Re: **Quinn Ave Short Plat (SP23002)**  
IECO No. 23-1265

The project referenced above is revised in response to the review comments dated July 13, 2023. The review comments are numbered on the letter and have been addressed in *italics* as follows:

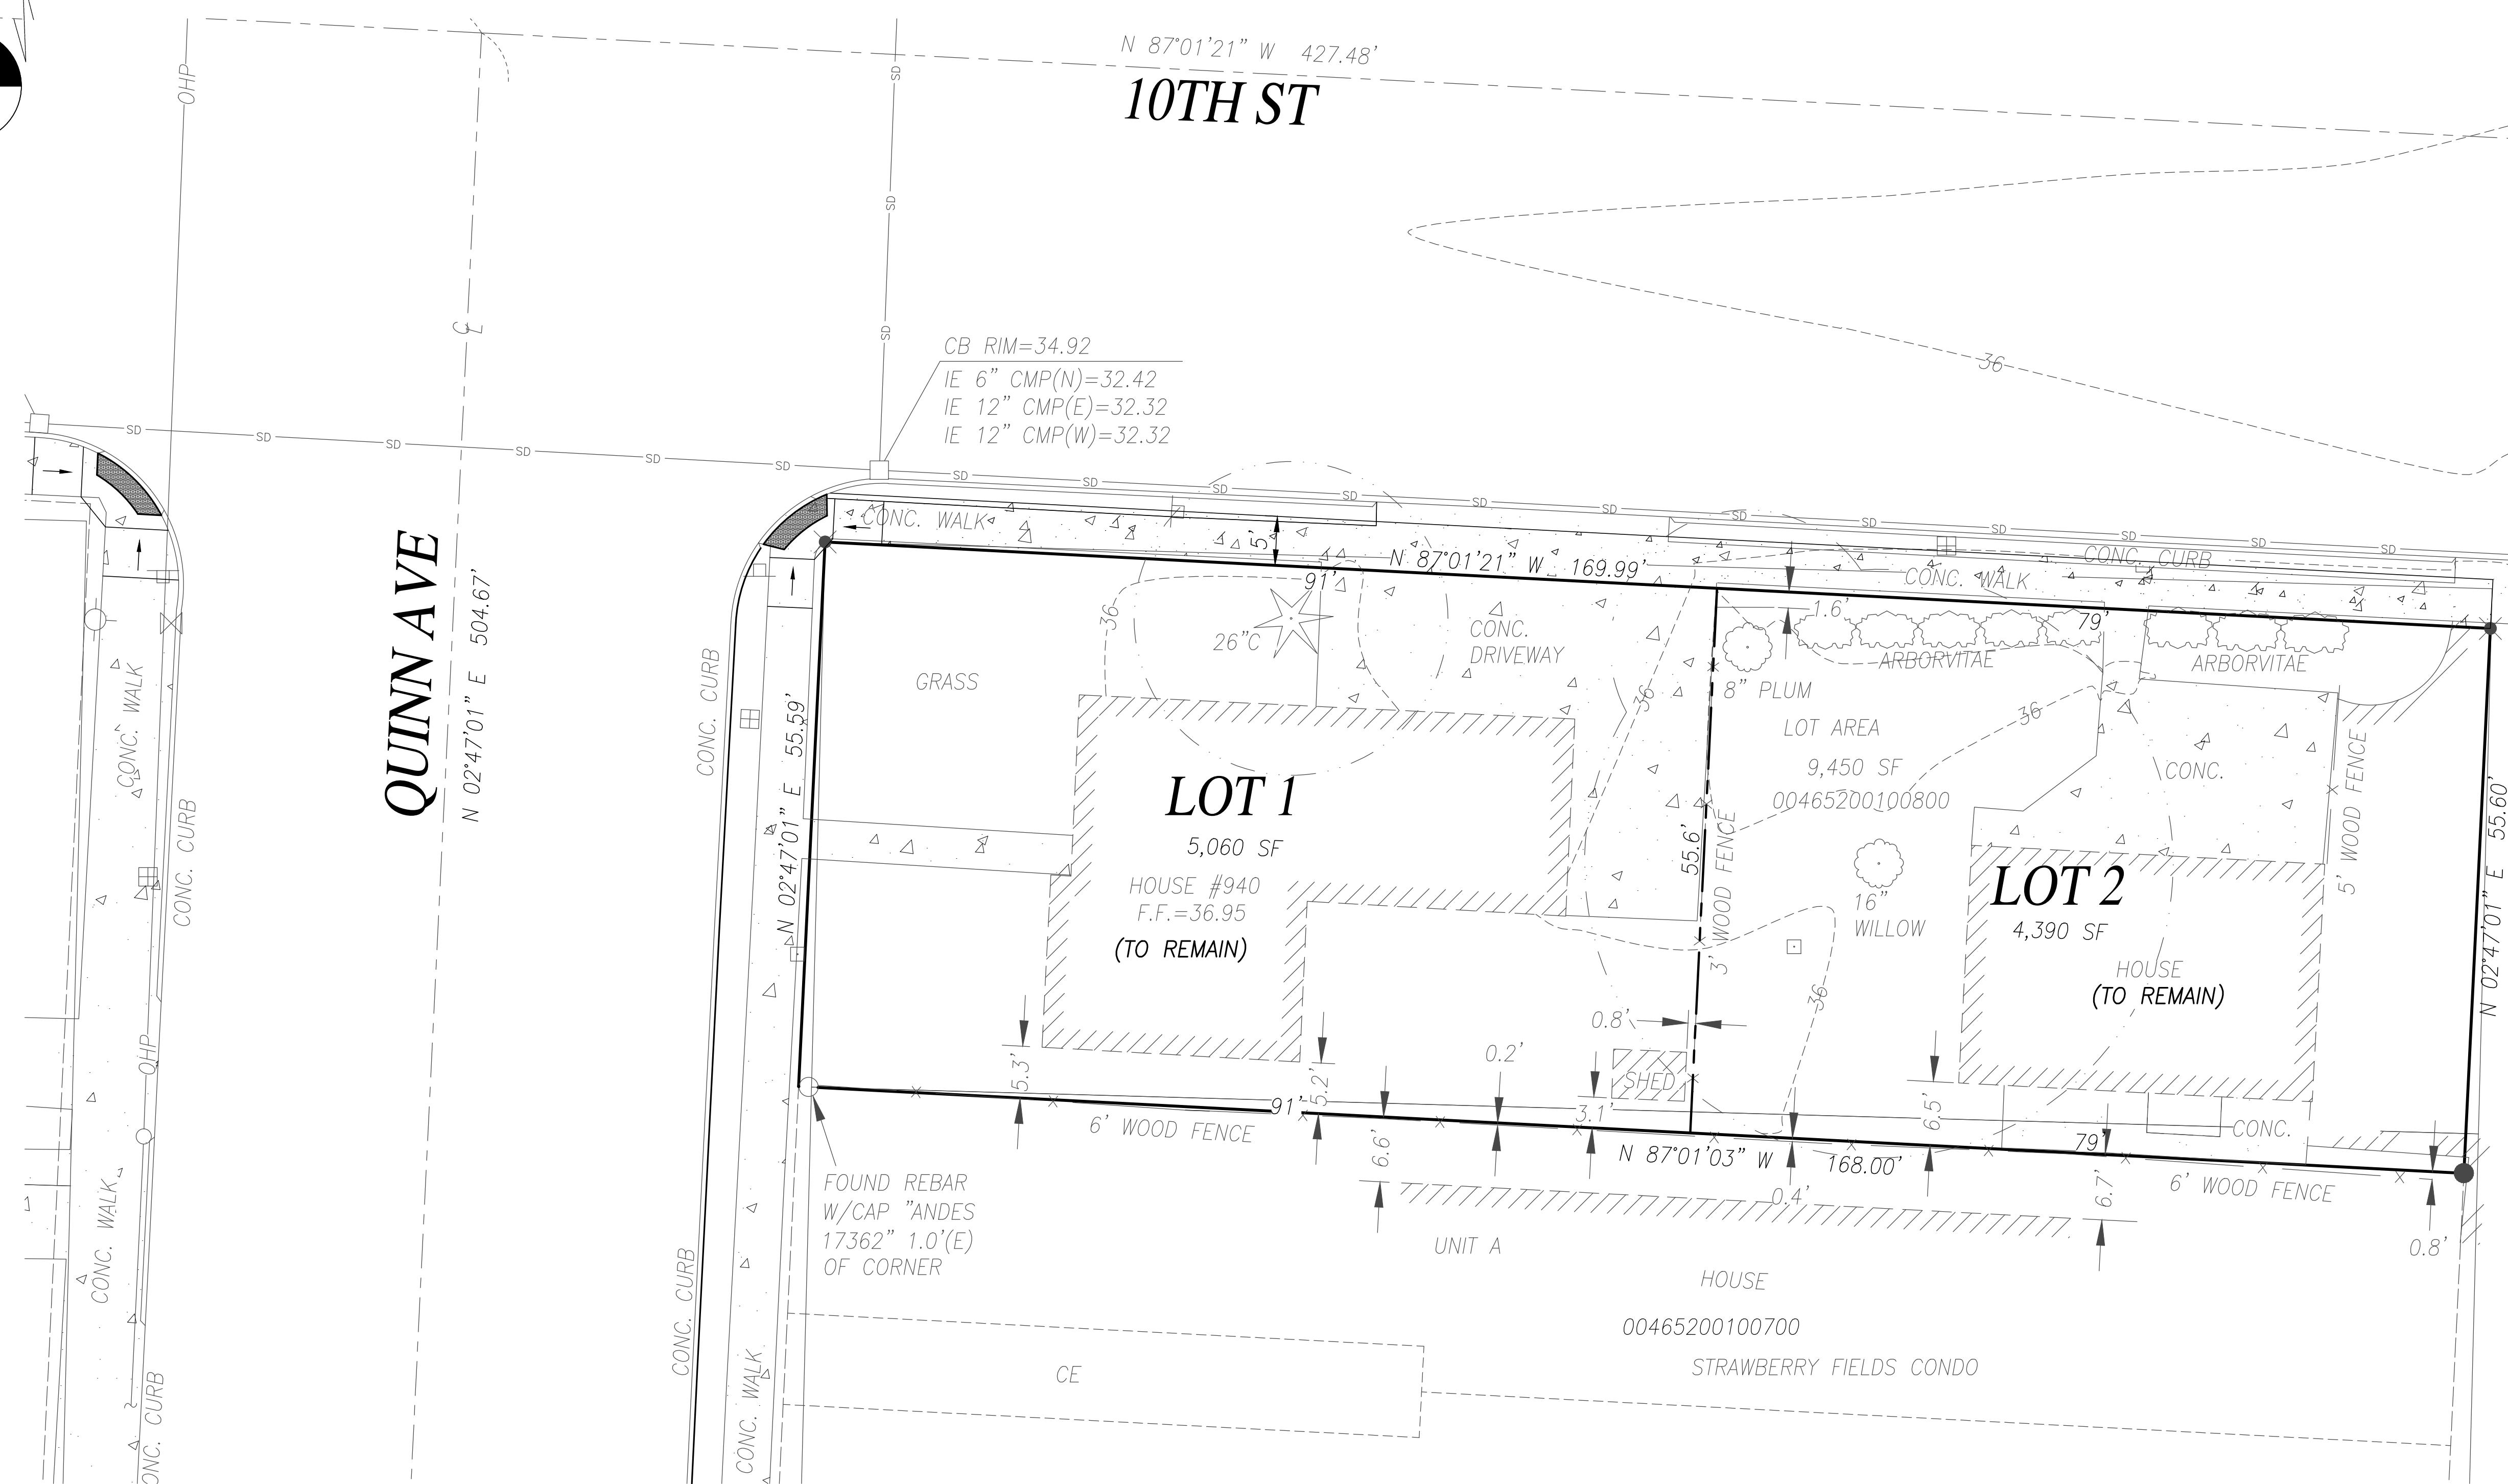
1. Please include file number SP23-002 on all future maps.

2. Amend the preliminary short plat map, as follows:
  - a. Change 'PERCEL NUMBERS' to 'PARCEL NUMBERS';

- b. Remove the parking stall numbers and solid black lines;

- c. Remove the building setback lines;

- d. Provide the following note:

The existing structures are considered legal nonconforming structures and uses and are subject to the provisions outlined in MMC Chapter 22C.100 Nonconforming Situations.

3. The existing shed located on the south-east portion of Lot 1 does not comply with the required minimum 5 foot side and rear yard setbacks and may be considered a legal nonconforming structure. Pursuant to MMC 22G.090.550, when divisions or redivisions of land are submitted proposing the creation of new lots with existing structures, the existing structures shall comply with all zoning code requirements including, but not limited to, such things as setback requirements, parking requirements and height standards; provided, however, if the structures are legal nonconforming buildings, nothing shall prohibit the division of such land, so long as the division does not increase or intensify the nonconforming nature of the structure.

The applicant shall be required to demonstrate the shed was legally constructed, or reconstructed to comply with the required 5 foot setback, prior to recording the short plat.

*The file number has been added to the short plat map, in the bottom left corner. Please see revised plat map.*

*The typo has been corrected. Please see revised plat map.*

*This has been removed. Please see revised plat map.*

*This has been removed. Please see revised plat map.*

*The note has been provided. Please see revised plat map, note 2 under the notes. Please see revised plat map.*

*A note, note 3, has been added to address this. Please see revised plat map.*

PRELIMINARY SITE PLAN

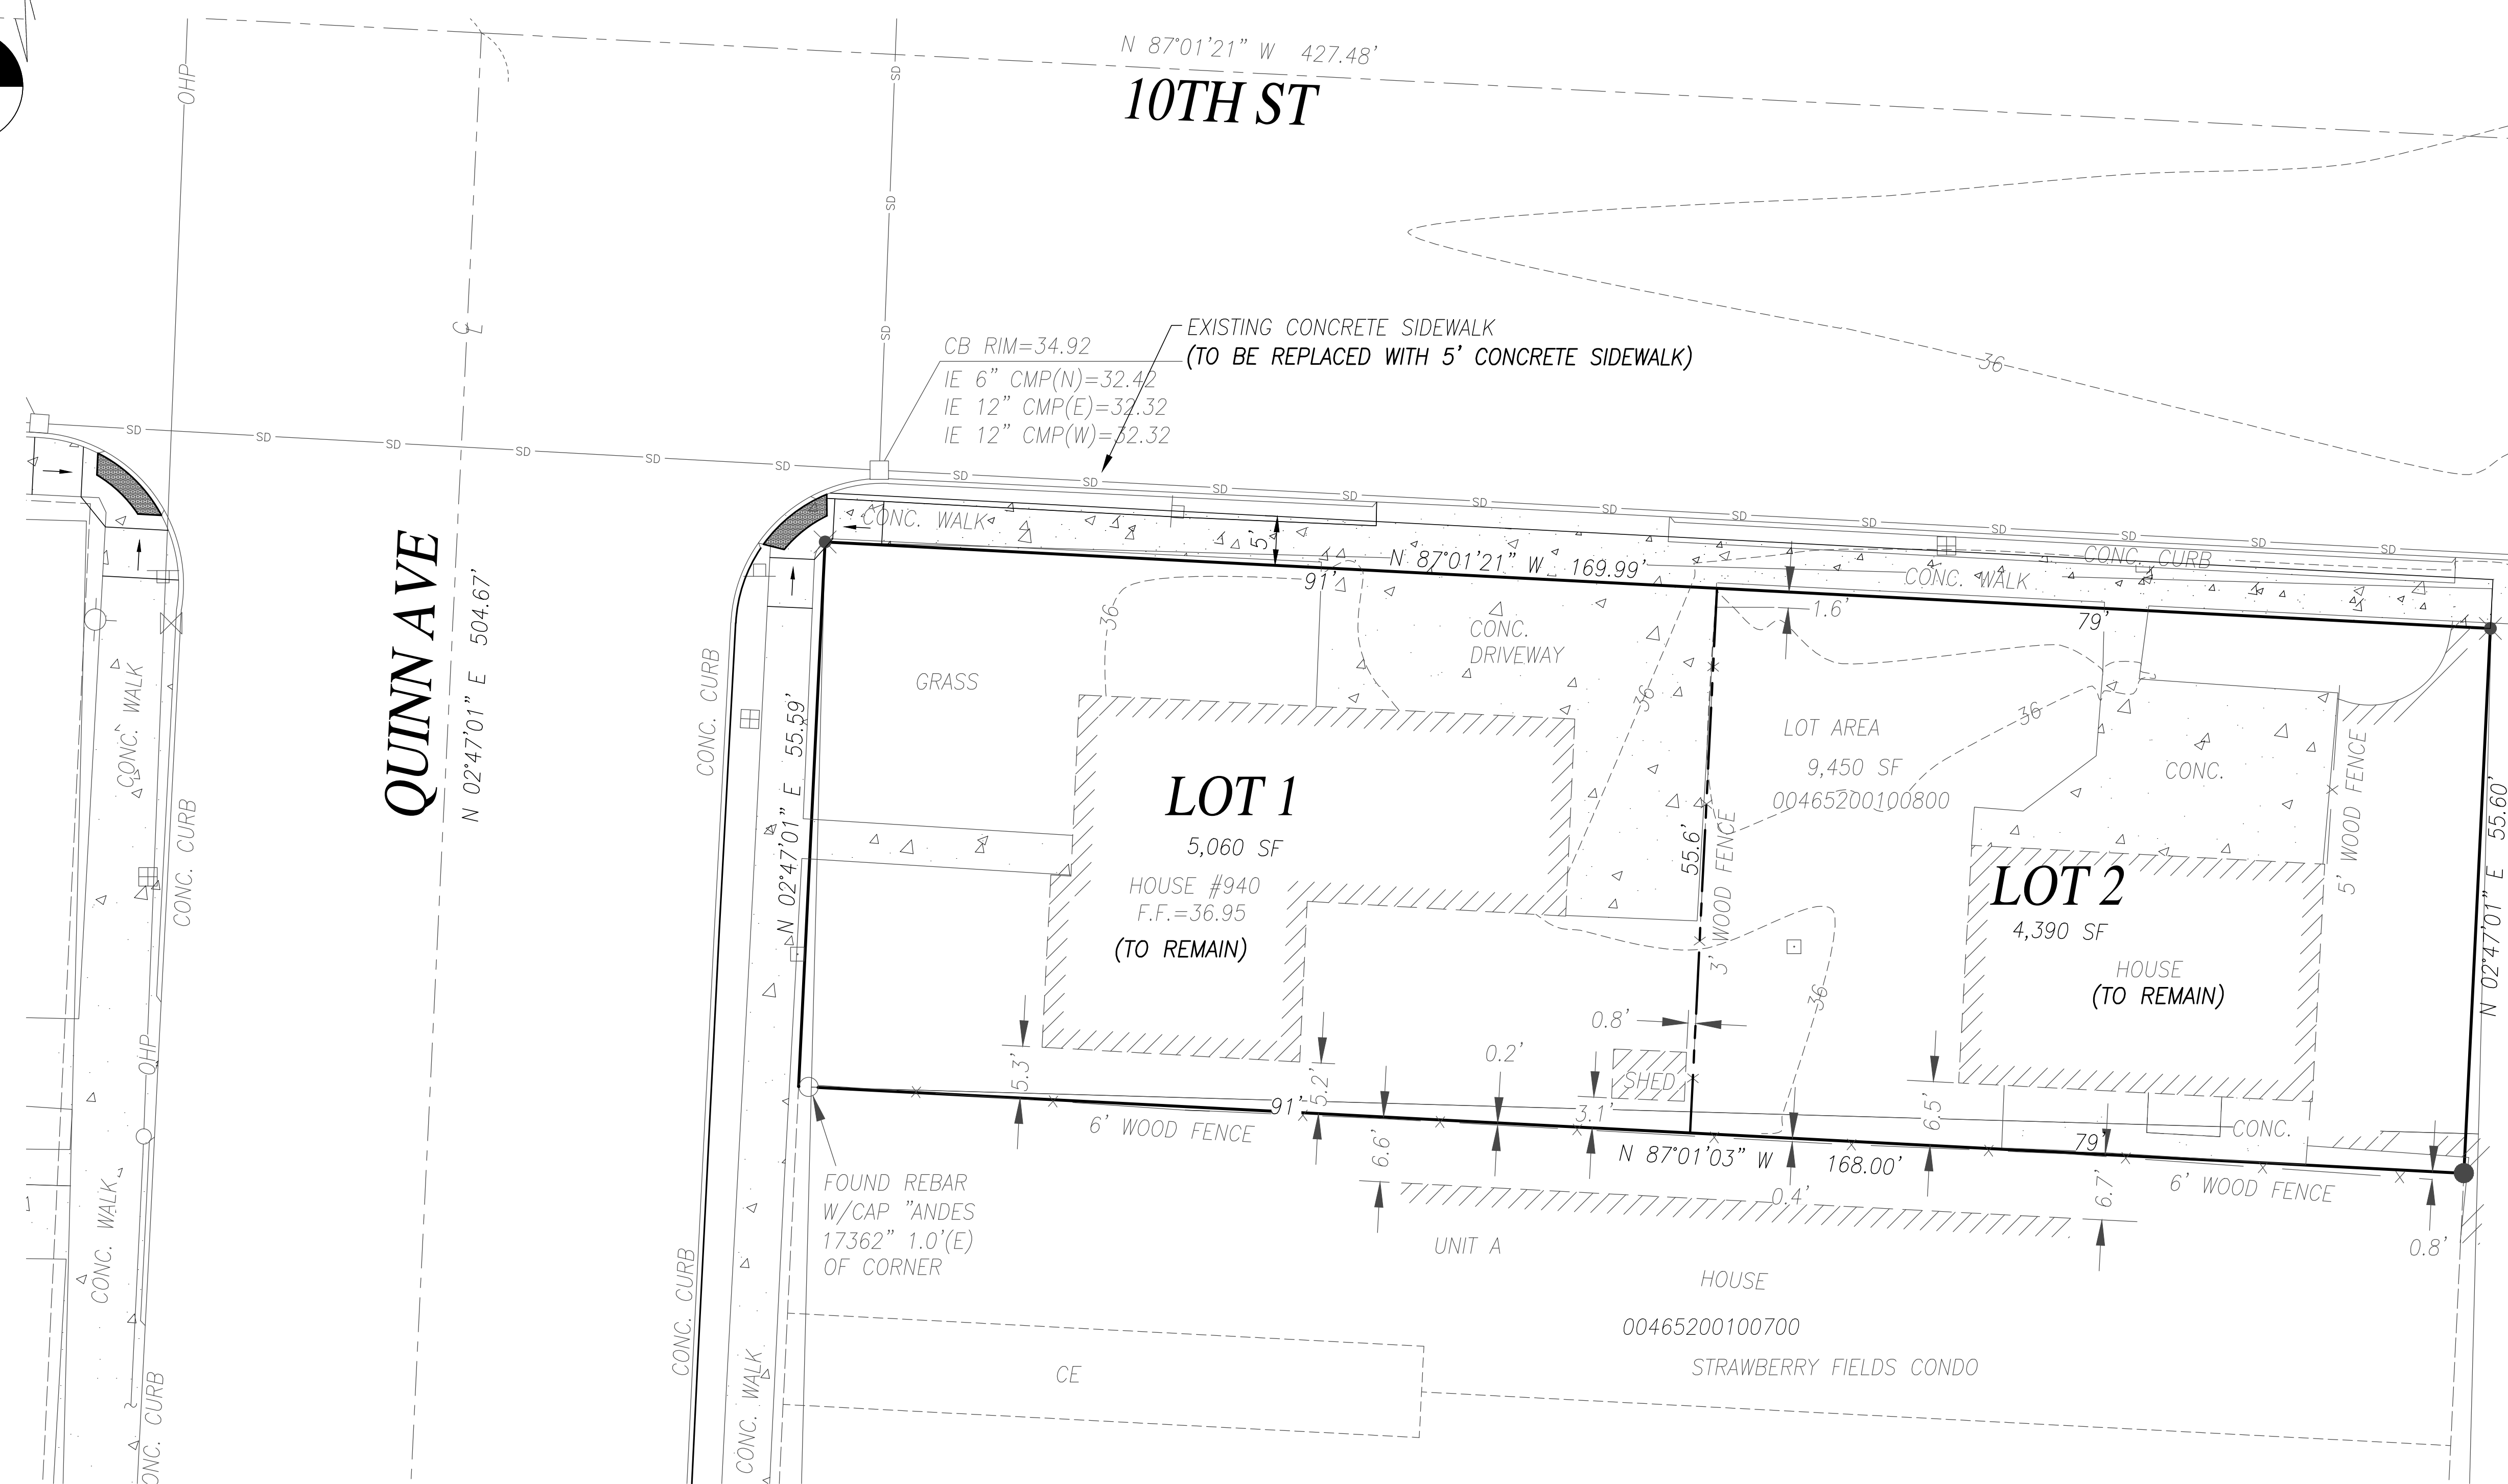
3. Frontage Improvements: Frontage improvements are required per MMC 12.02A.090 on all projects. Frontage improvements are described as curbs, gutters, and sidewalks; underground storm drainage facilities; patching the street from its preexisting edge to the new curb line; and overlayment of the existing public street to its centerline.
  - a. At this time it looks like the roadway is expanded to the City standard. The sidewalks fronting the parcel should be removed and replaced with a 5 foot wide sidewalk.

10. The 2 existing structures may be sharing the same side sewer hookup. At a minimum an easement will need to be placed, and possibly a new tap into the sewer in the alley.

*The sidewalk widening is shown on the engineering plans*

*Both units are currently hooked up to sewer. The exact location of the side sewer could not be found so a note has been placed on the plans to allow the side sewer continuous use after recording.*
